PDW/17125

May 02 2018

APPLICATION FOR RESERVED MATTERS APPROVAL (EG/6/18/RES) COMPRISING LAYOUT, SCALE, APPEARANCE AND LANDSCAPING PURSUANT TO OUTLINE PERMISSION (EG/71/14/OUT) FOR THE ERECTION OF 60 DWELLINGS, VEHICULAR ACCESS OPEN SPACE AND ANCILLARY WORKS ON LAND AT THE FORMER EASTERGATE FRUIT FARM PO20 3RP

drawing: Soft Landscape Proposals

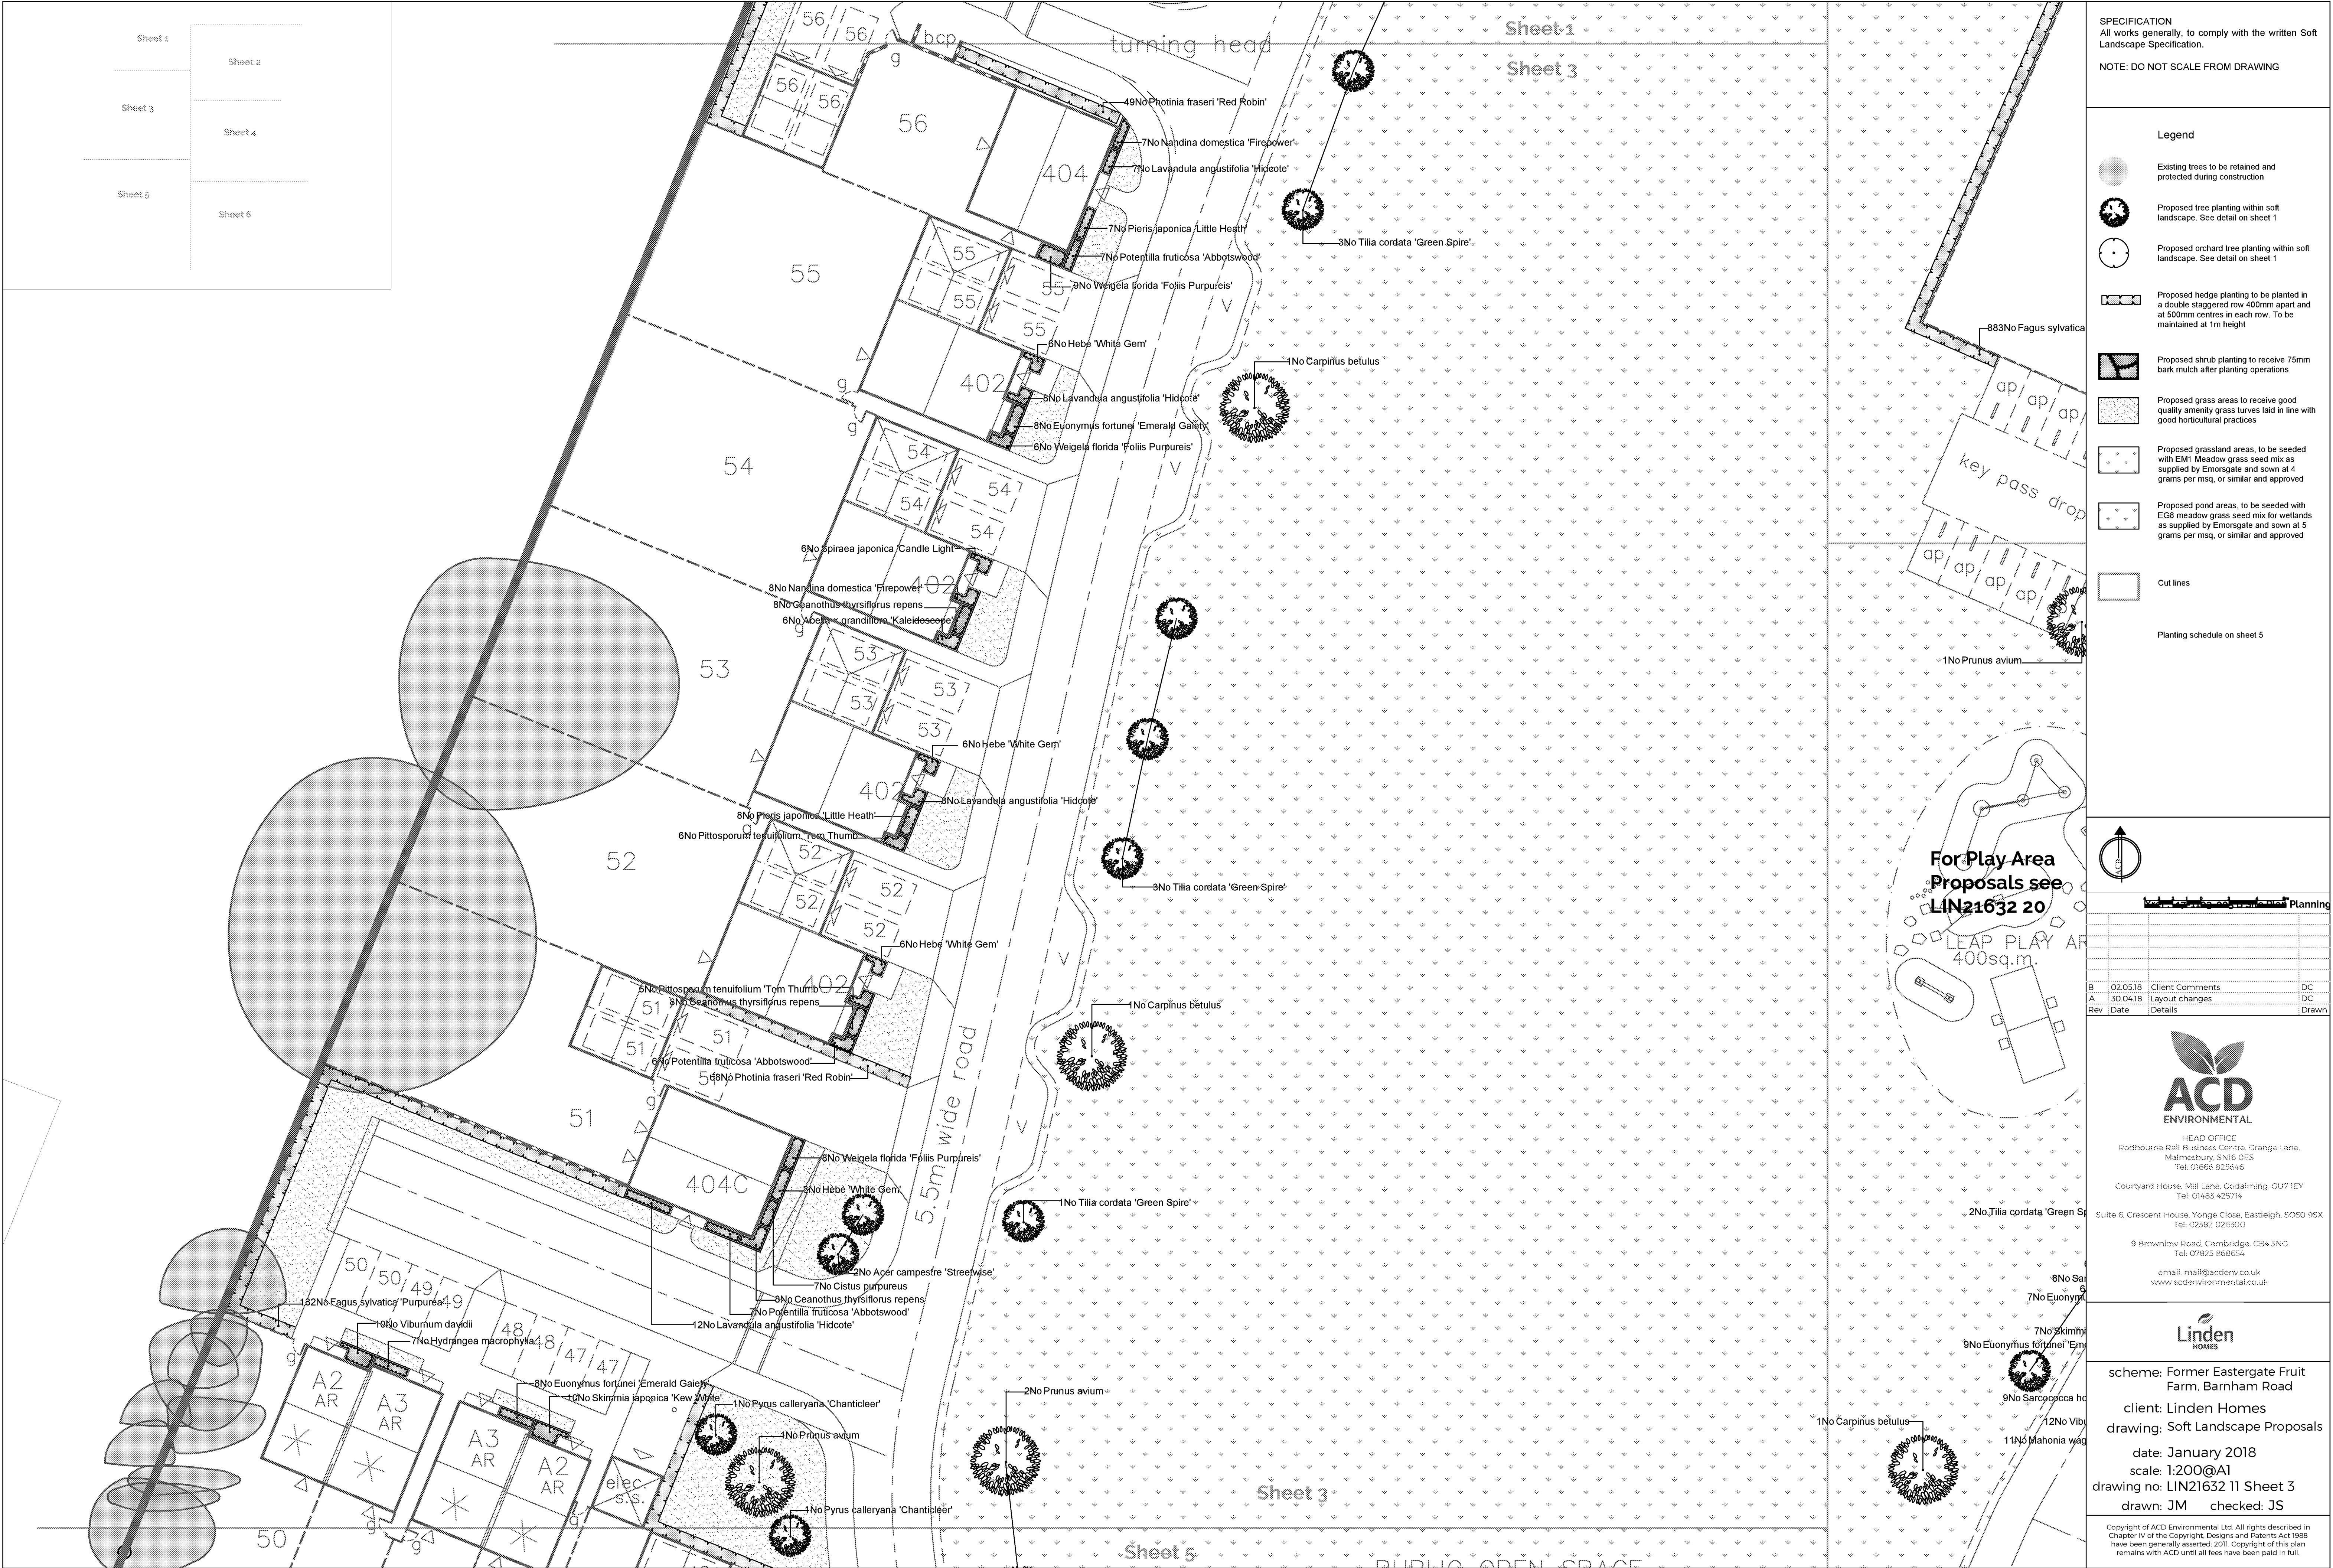
The revised plans pick up the minor highways comments of WSCC, the urban design comments of Mr Edwards and Sussex Police. As agreed at our meeting on the 25th April, the comments of Mr Warwick requiring a Tree Protection Plan can be dealt with by planning condition and will not delay determination of the Reserved Matters application. In summary the Site Layout revisions (all captured on the landscape plans) show:

- The internal junctions within the site have been amended and a cross roads introduced.
- The kerb radii at the junction serving plots 1-5 and plots 6-45 has been tightened.

- The junction serving plots 46-50 and plots 51-60 has been improved giving the former better priority with some deflection for traffic to the latter.
- A turning head has been added by Plots 59 and 60.

- The 2 on street visitor parking bays opposite plots 32-36 and the parallel bays close to plots 28-31 have been relocated close to plot 7.
- Parking to the rear of plots 56-57 has been made more accessible with a path connection.

- The footpath between plots 22 and 23 has been deleted.
- The allotment parking has been secured with drop down bollards and LEAP parking spaces allocated.
